Our Ref: A17143LRMP

6 April 2018

RE Office of Environment and Heritage comments on Notification of Modification Seniors Living Housing Development, 34-36 Memorial Avenue, Kellyville (MP09_0180 MOD 7)

Drawing Number **DA221**
Revision **A**

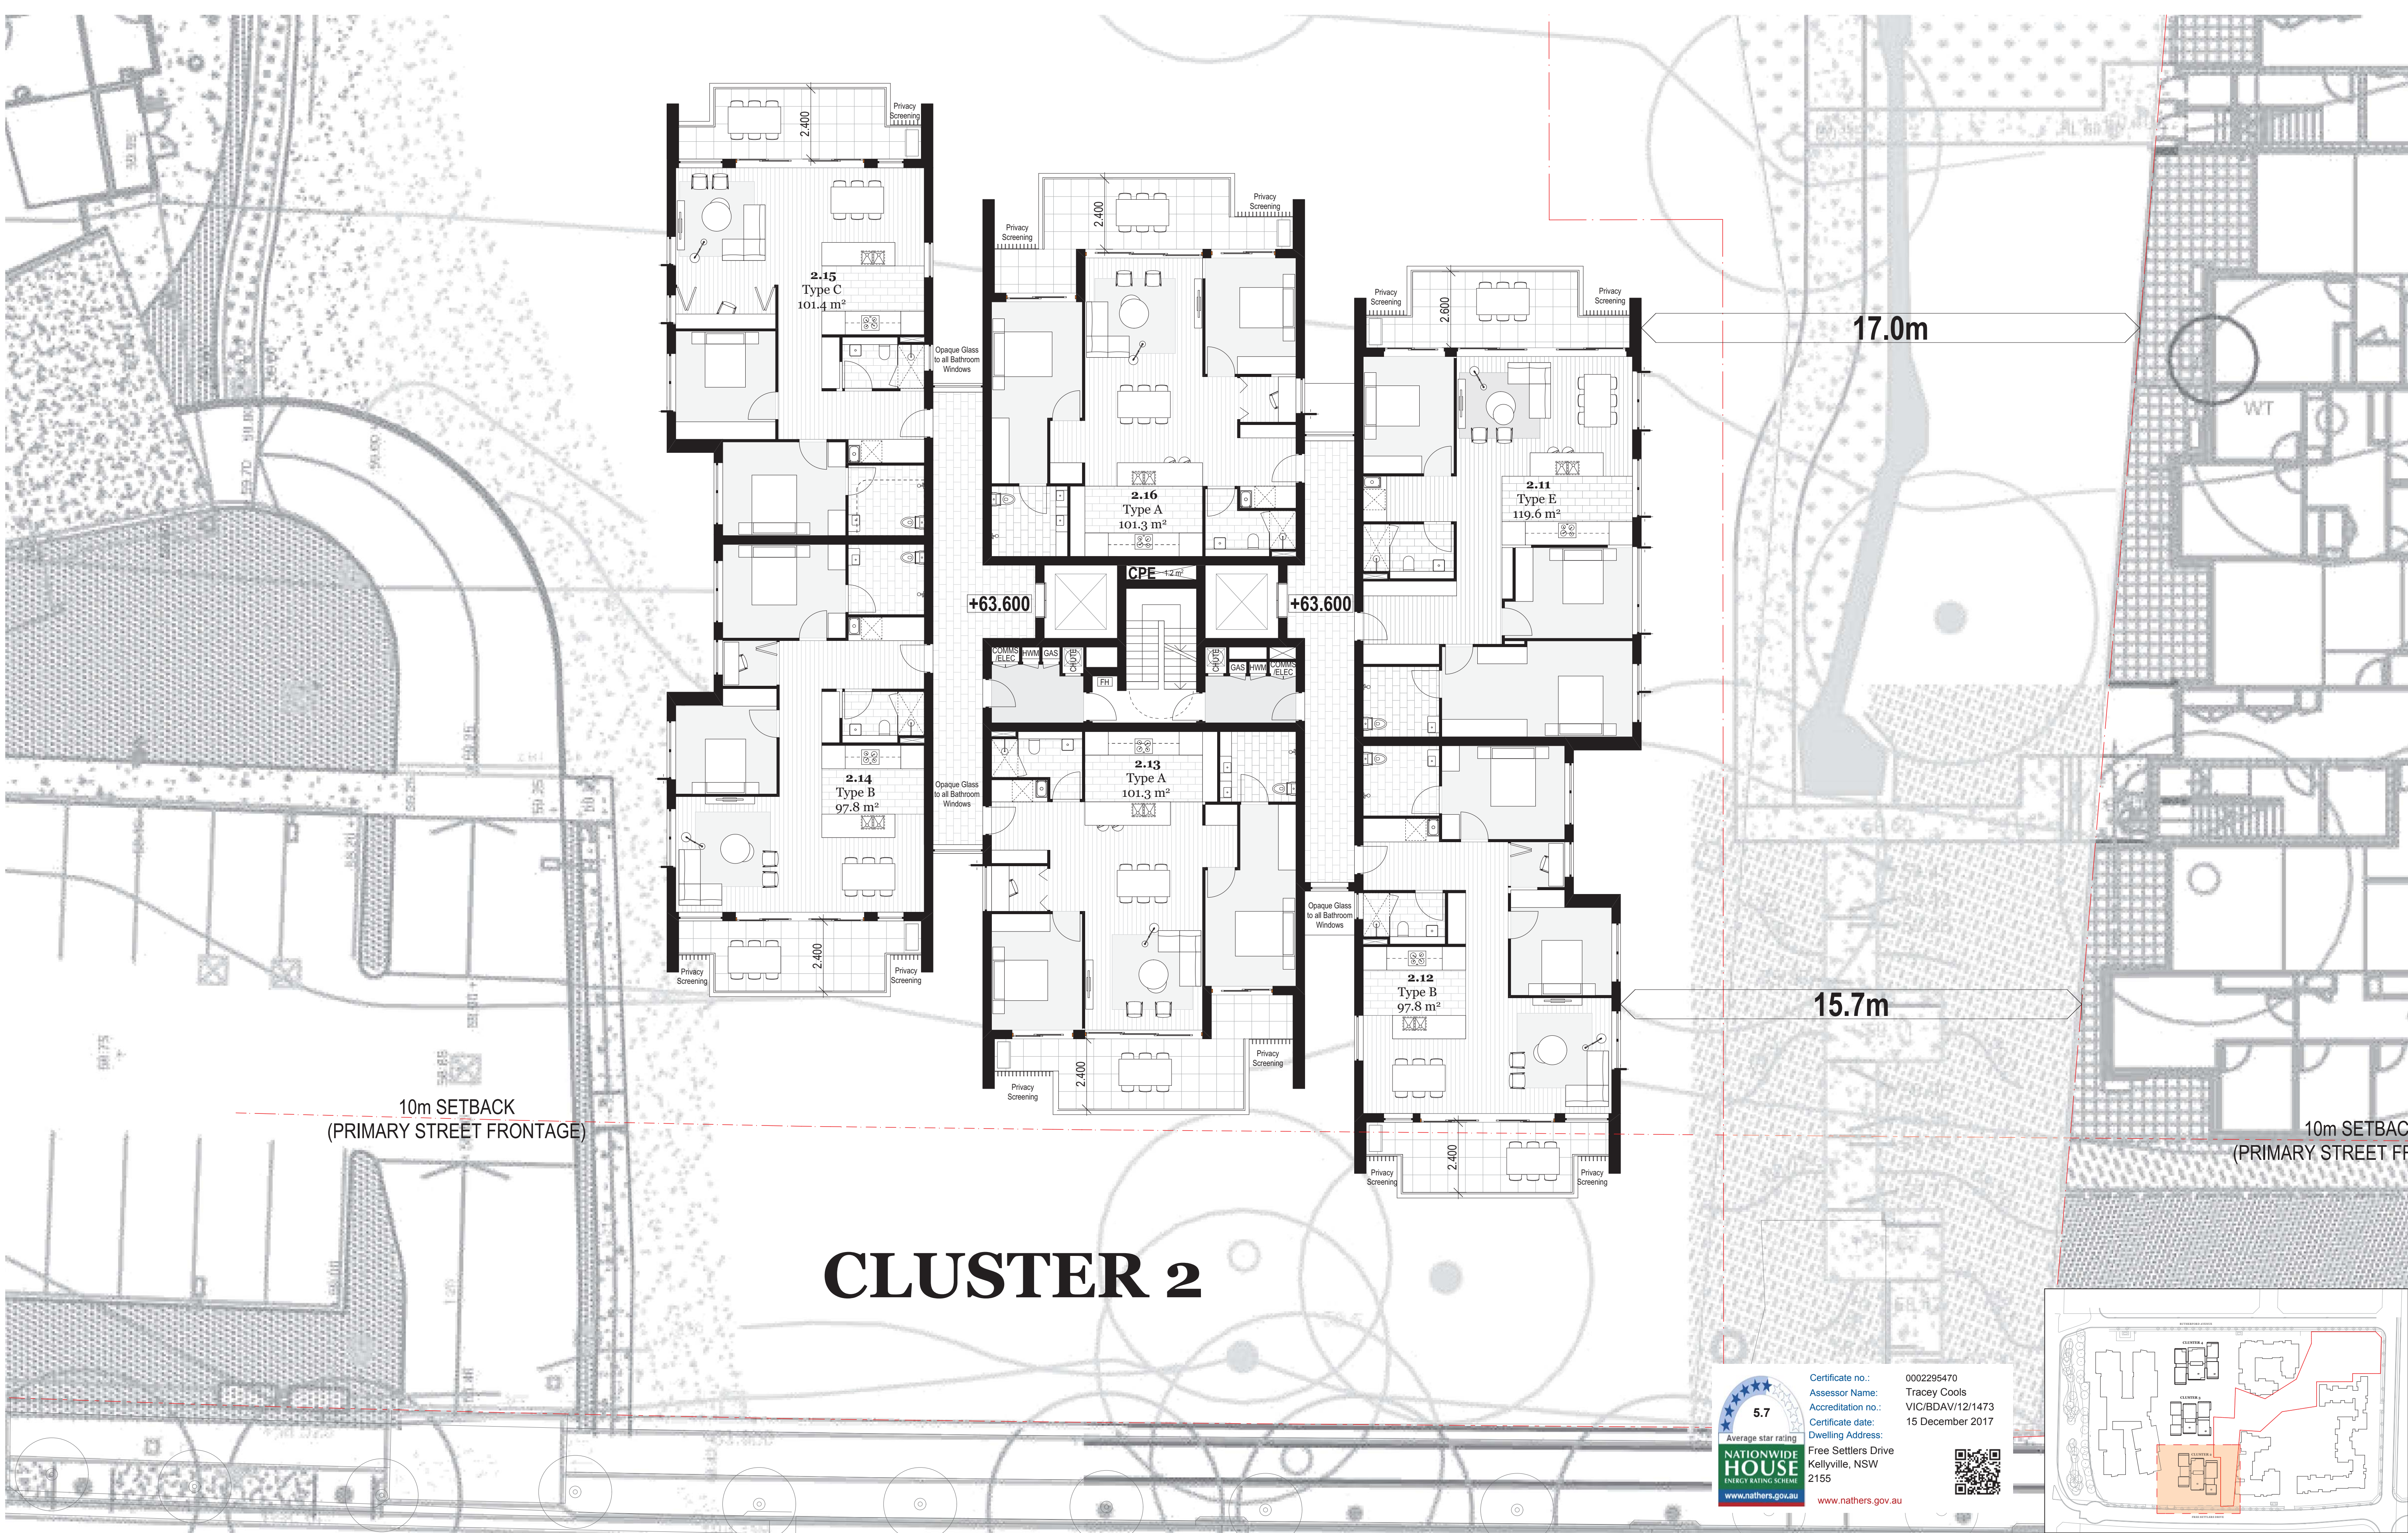
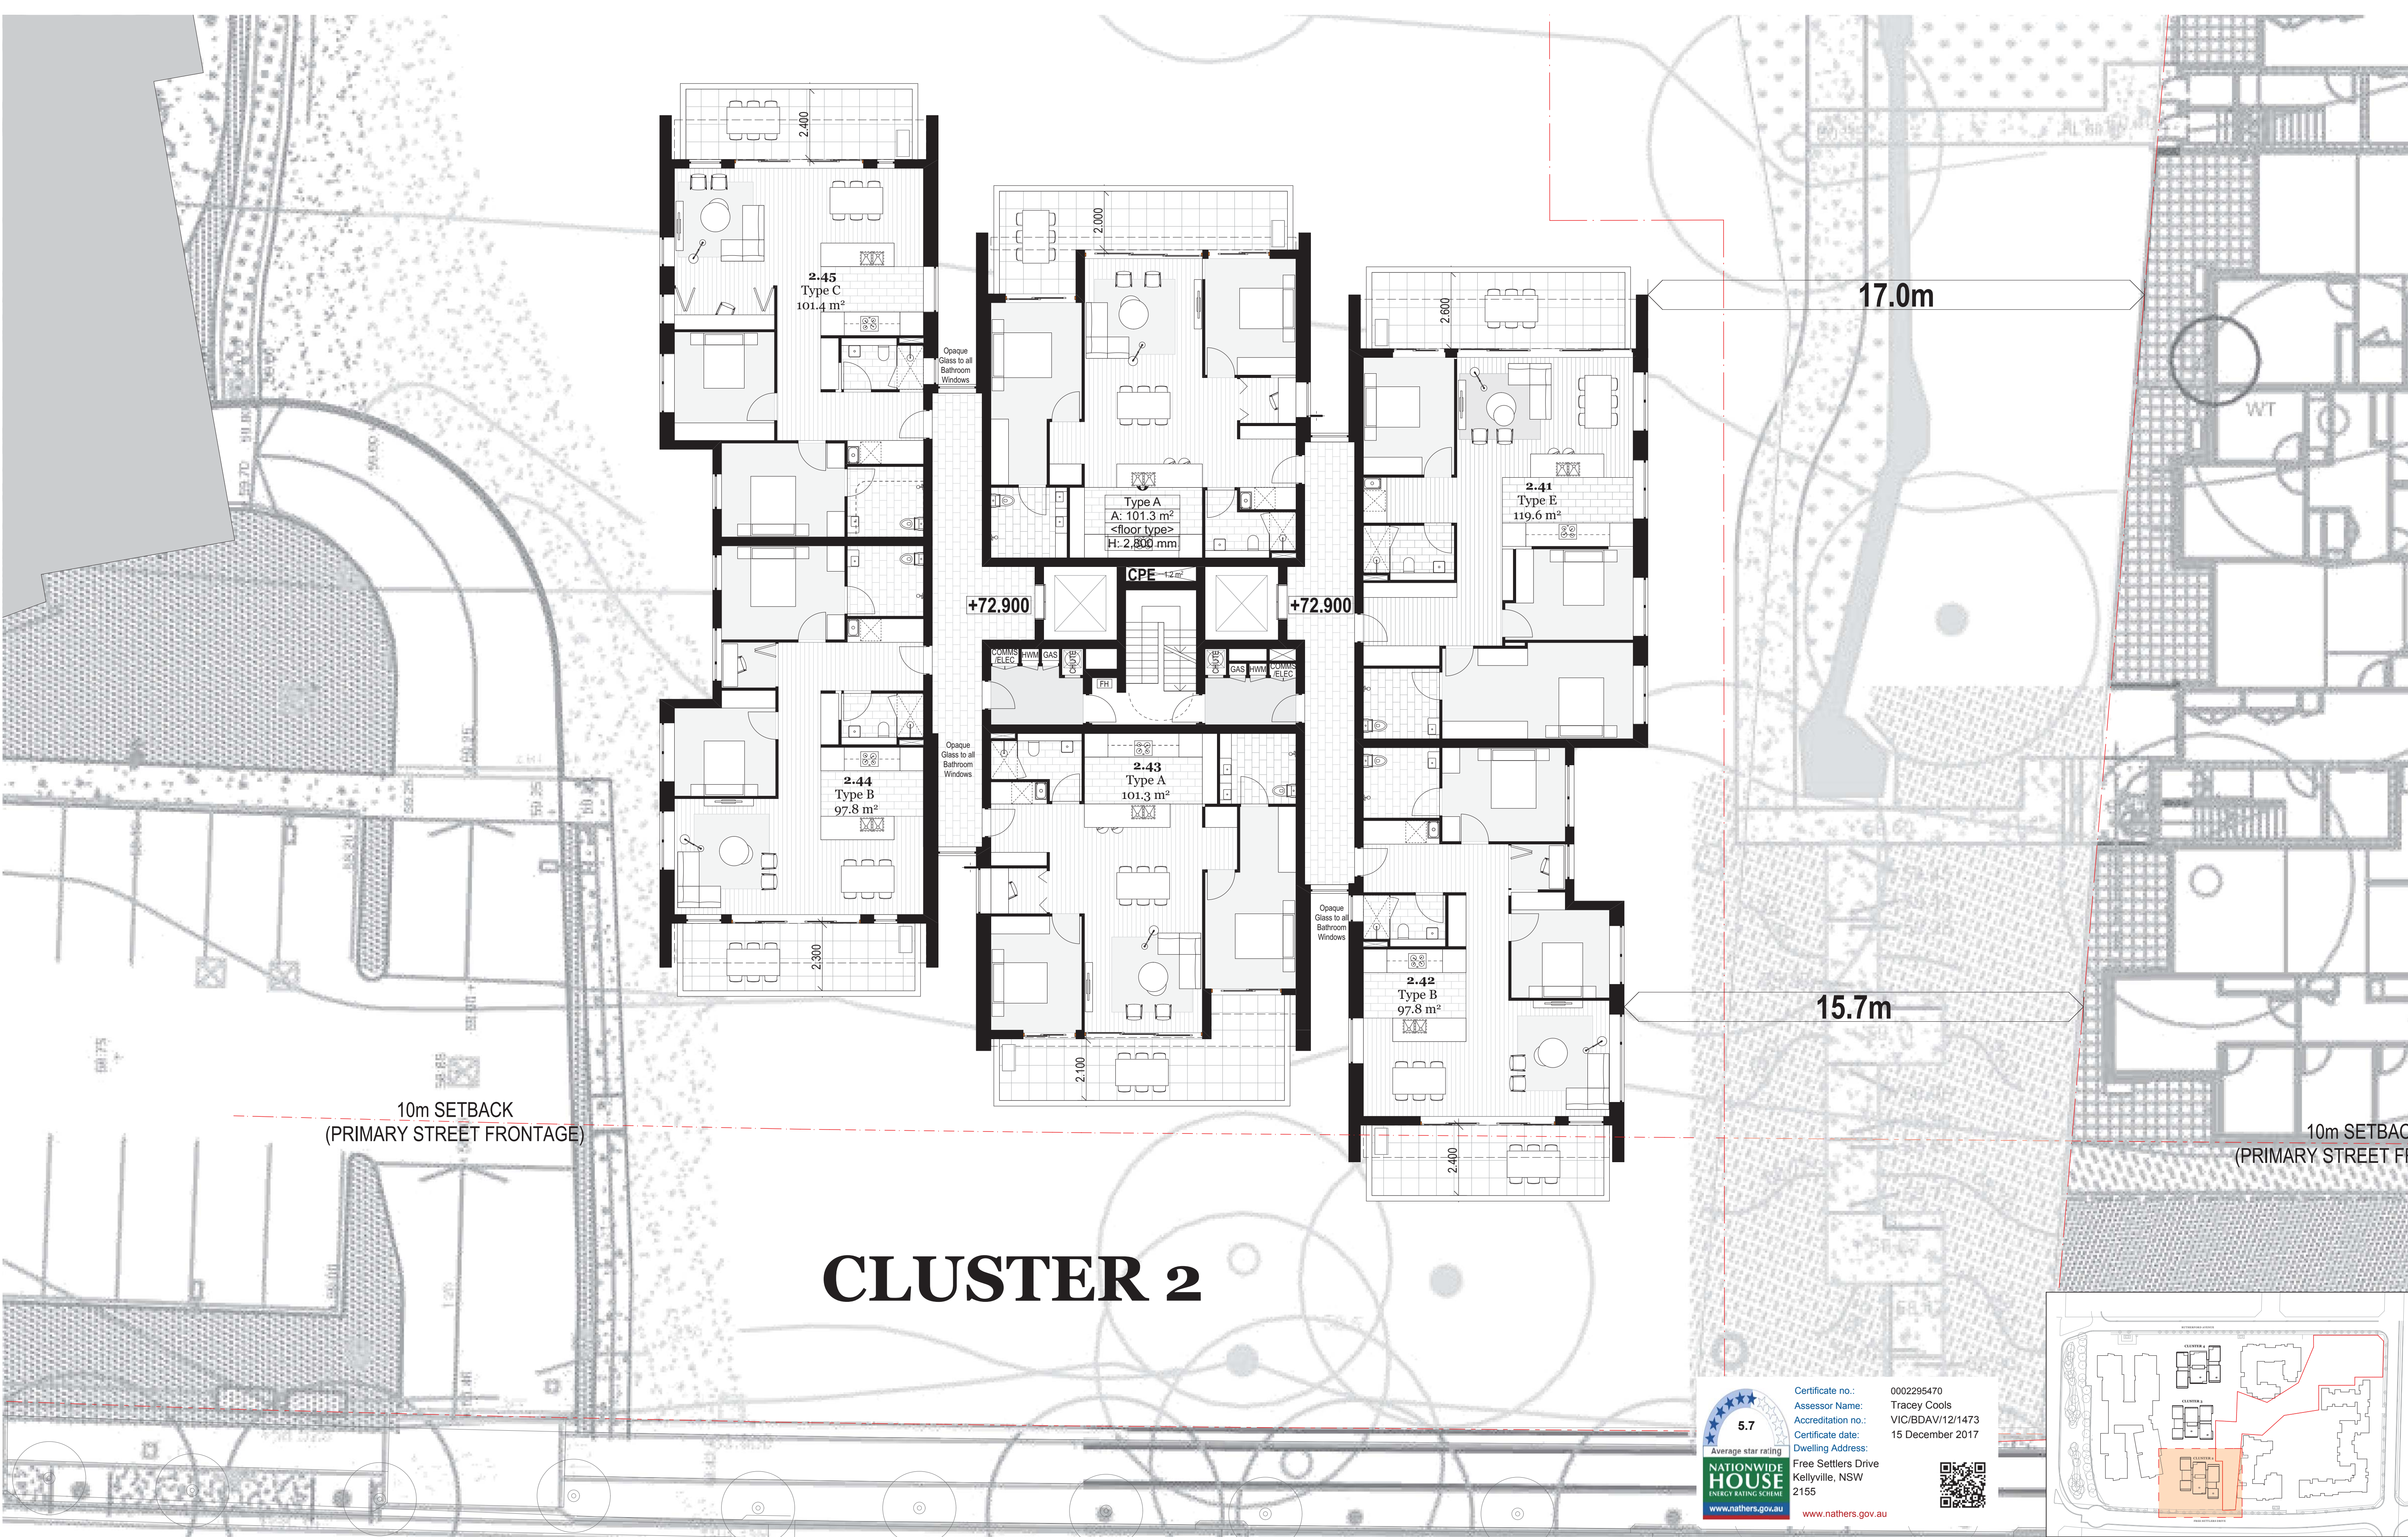
OEH Comment	Response
Tree retention and removal	
The EA indicates that while a change in the building footprints is proposed, the total area of CPW will be maintained at a minimum of 0.5421ha. The change in building footprint will however impact a total of 7 trees (T024, T025, T027, T037, T048, T049 and T050) (Section 4.2.7 of EA, page 9). It notes that apart from T027 all the other trees were previously indicated for removal as part of the previous studies and that T052 which was previously to be removed is now being retained as part of the MOD 7 development.	Noted however T024 & T037 have already been removed
OEH notes the 7 trees to be removed are Narrow-leaved Ironbark <i>(Eucalyptus crebra)</i> as is T052 (Schedule 1 of Tree Assessment).	TBE confirms that 5 trees (excluding T024 & T037) will be removed
OEH acknowledges and supports the retention of T052 but seeks clarification as to whether there is any potential to modify the footprint of the proposed buildings to avoid removing T027 (and/or any of the other 6 trees which have previously been indicated for removal). It appears, for example the reason why T024 and T027 are proposed to be removed is that the structural root zone of these trees slightly overlaps with the proposed footprint of the buildings (see Schedule 2 of Tree Assessment). If there is no potential to retain these trees, their loss should be offset.	As recently discussed with Janne Grose (OEH) the retention of T052 was a result of reviewing the building footprint. Offsetting the loss of five trees is a negligible outcome in terms of offset credits but they can be replaced within the proposed landscaping of the CPW Reserve or replanted as part of landscaping in a more sustainable location Offsetting the loss of CPW reserve will be an offset for the loss of a highly degraded portion of the CPW reserve and it will have a very low site value score based on its condition. It is the clients preference to replant and recreate a high quality CPW outcome within the site.

- Installation of 23 repurposed natural hollows instead of nest boxes which are already in high density with the reserve.
- To replace damaged or lost nest boxes within the reserve with repurposed natural hollows or nest boxes.
- Planting of a minimum 28 new CPW trees within the CPW open space reserve and 10m defendable zone which achieves a 5:1 offset ratio.
- Harvesting of up to 4 trunk sections 3-4m in length to be relocated onto the CPW reserve for on-ground habitat.
- Implement monitoring of the nest boxes and hollows.
- Update the Landscape restoration management plan and landscape plans to reflect the above outcomes.
